Deadline 5 Submission.

6.1. Chapter 5 Landscape and Visual Impact 15 July 2026

#### Local Landscape Character Areas

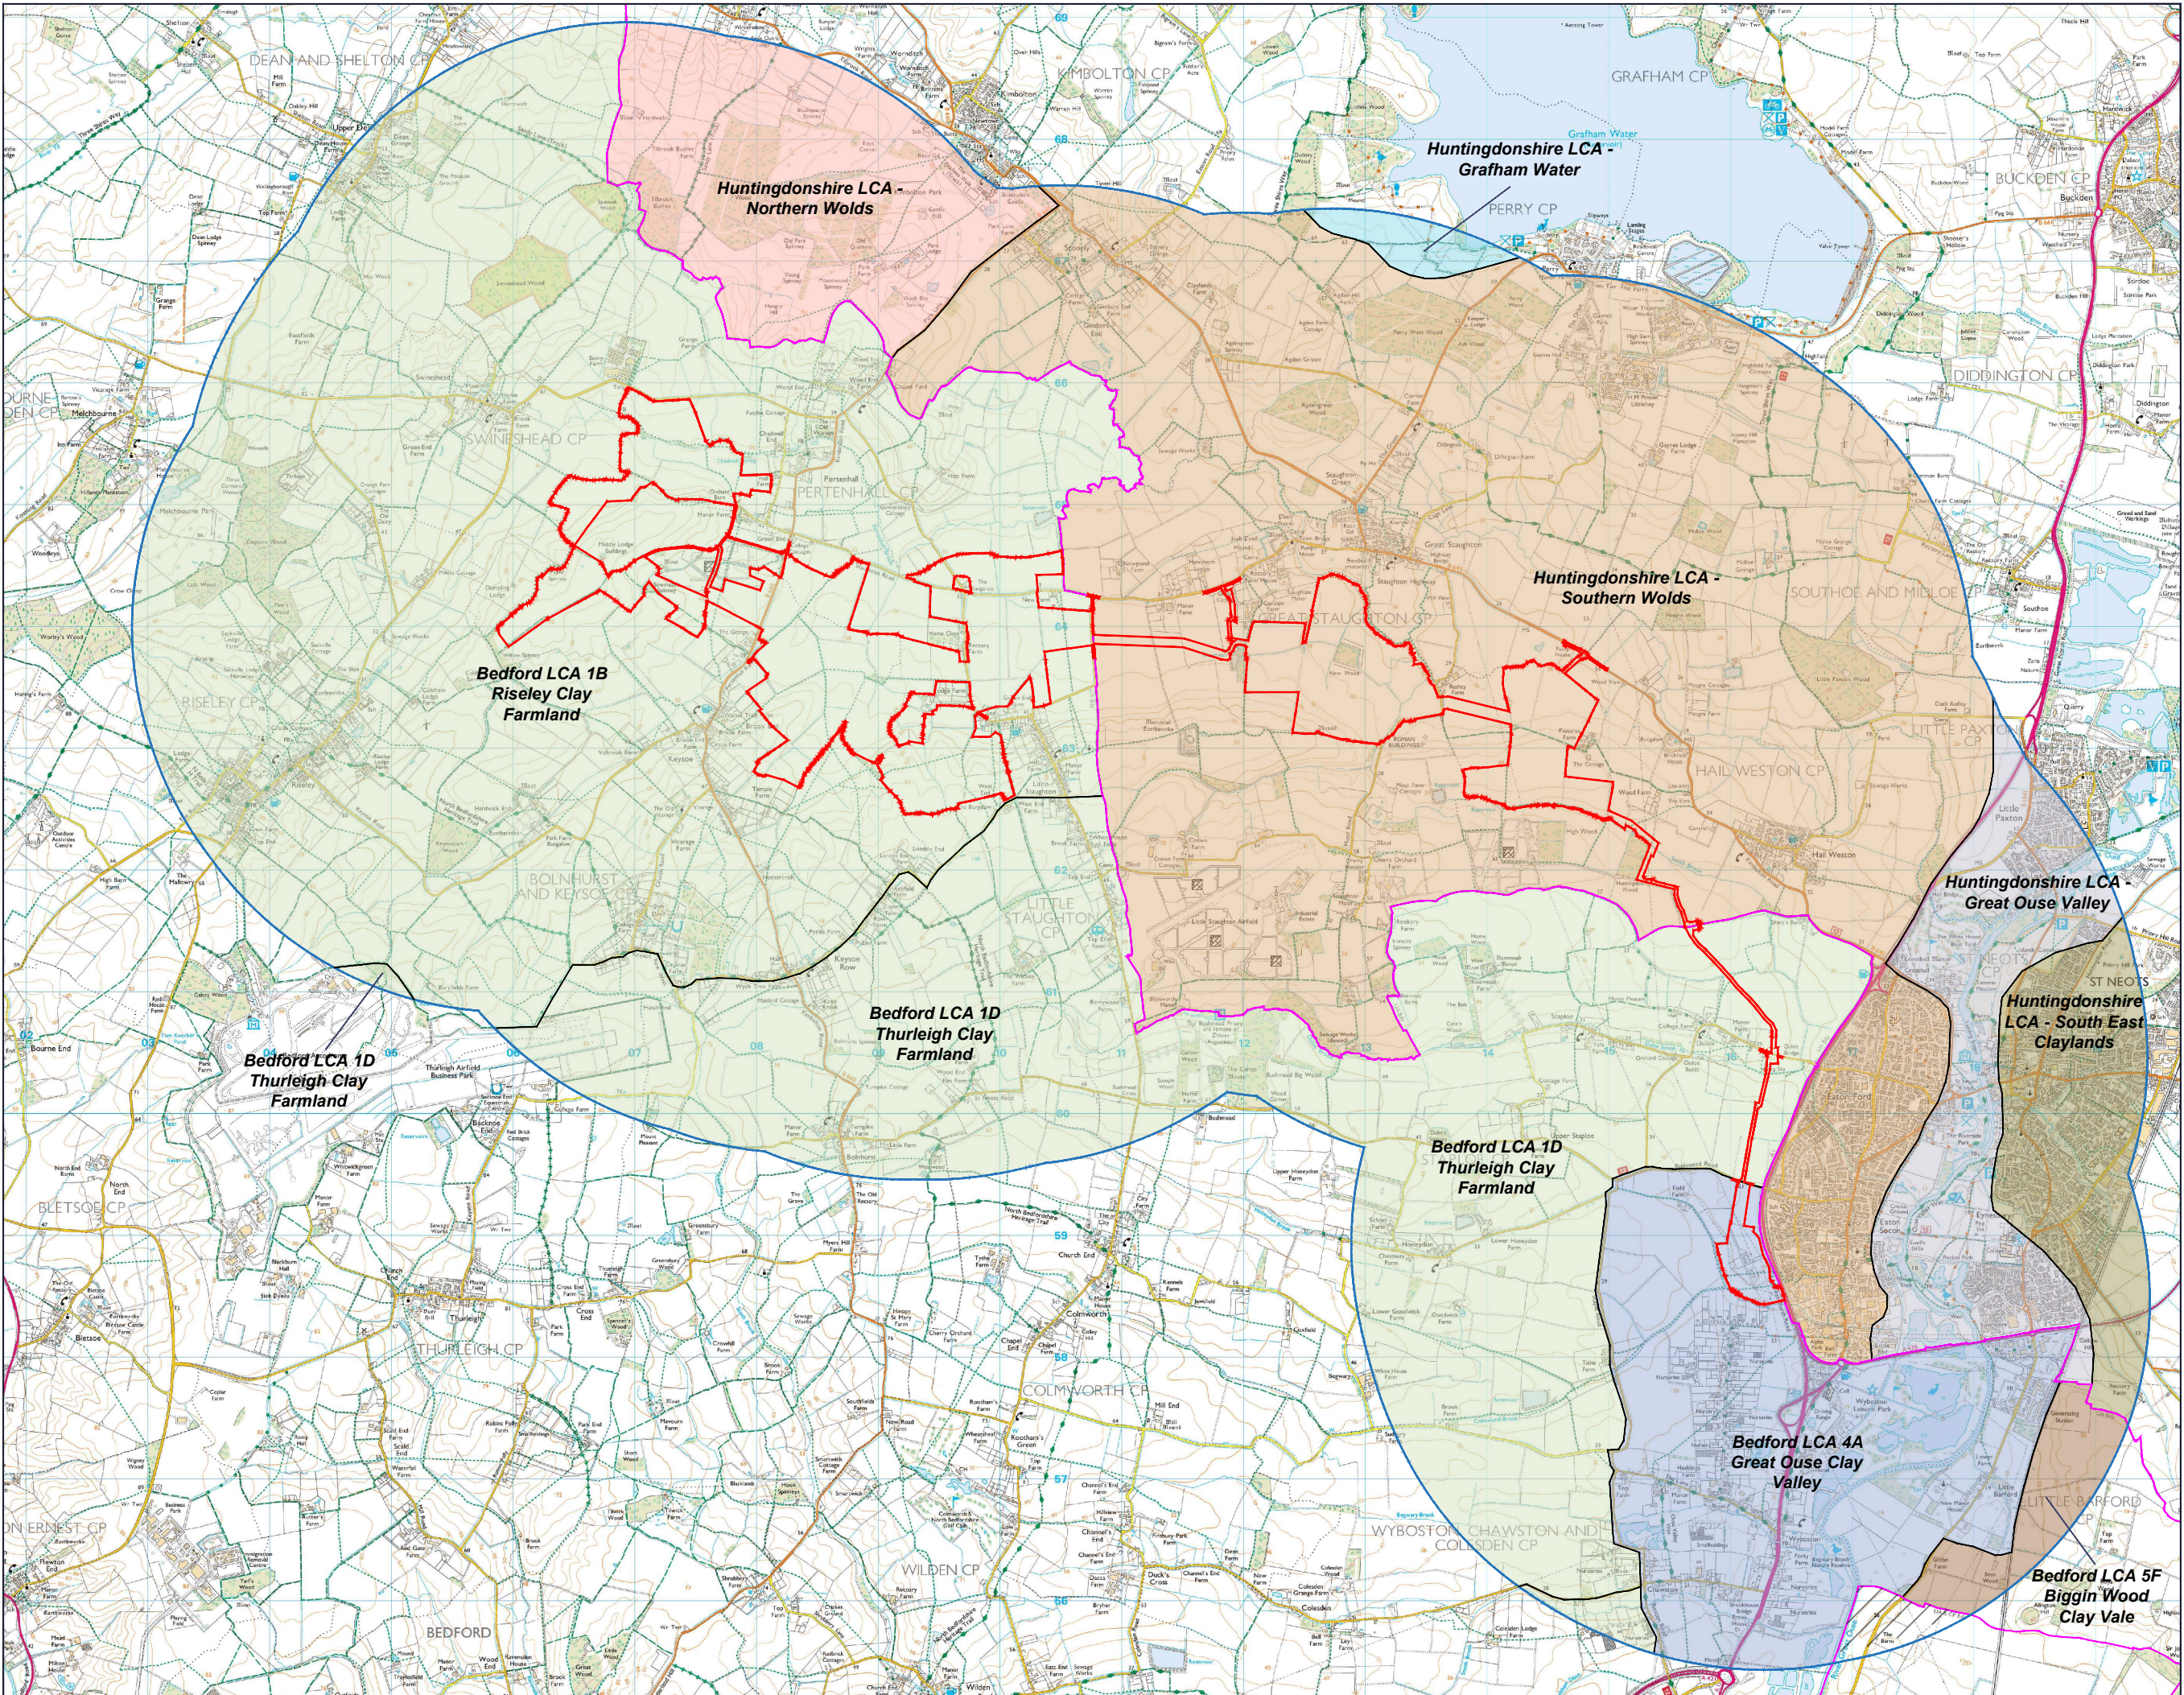
I would draw attention to the fact that the Riseley Wolds are constantly throughout the document referred to as 5.6.28. Riseley Clay Farmland not as shown in all Borough documents including the Local Plan.

Drawing Title  
**Visual Receptors - Representative Viewpoints & Rights of Way**

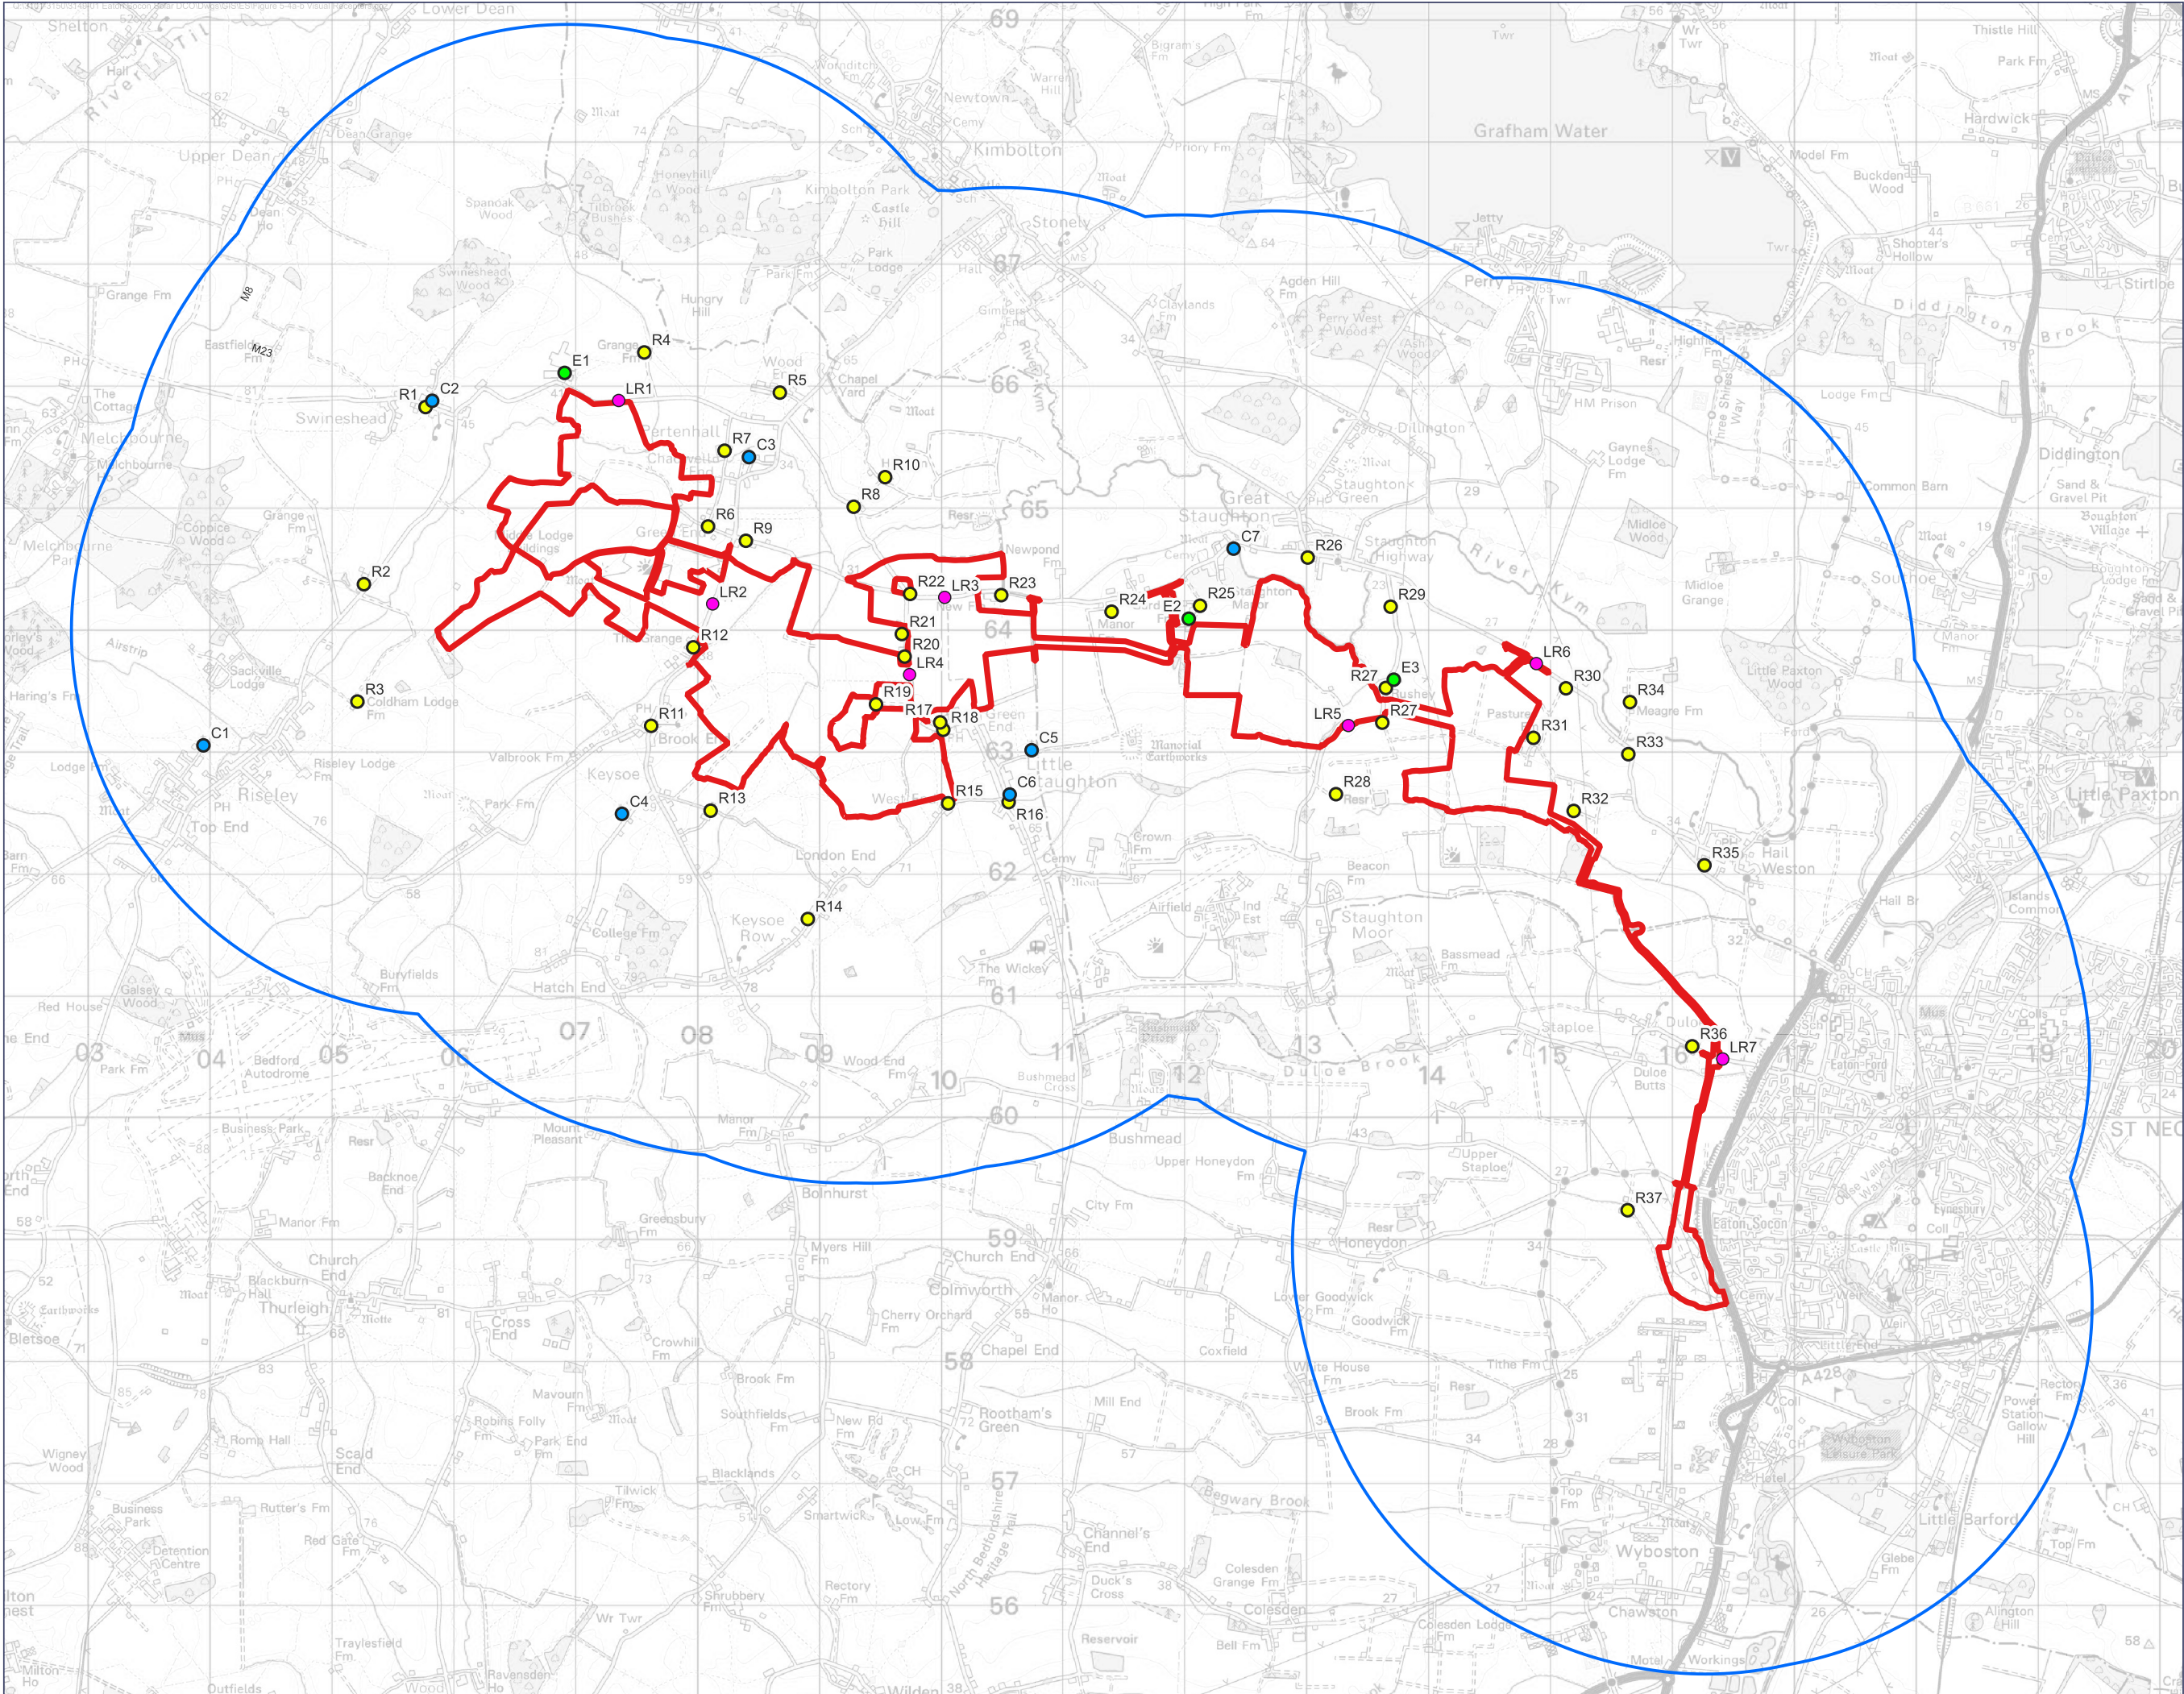
The charts in 5.8.44 show that there will be a significant detrimental effect on a high number of the PROWS
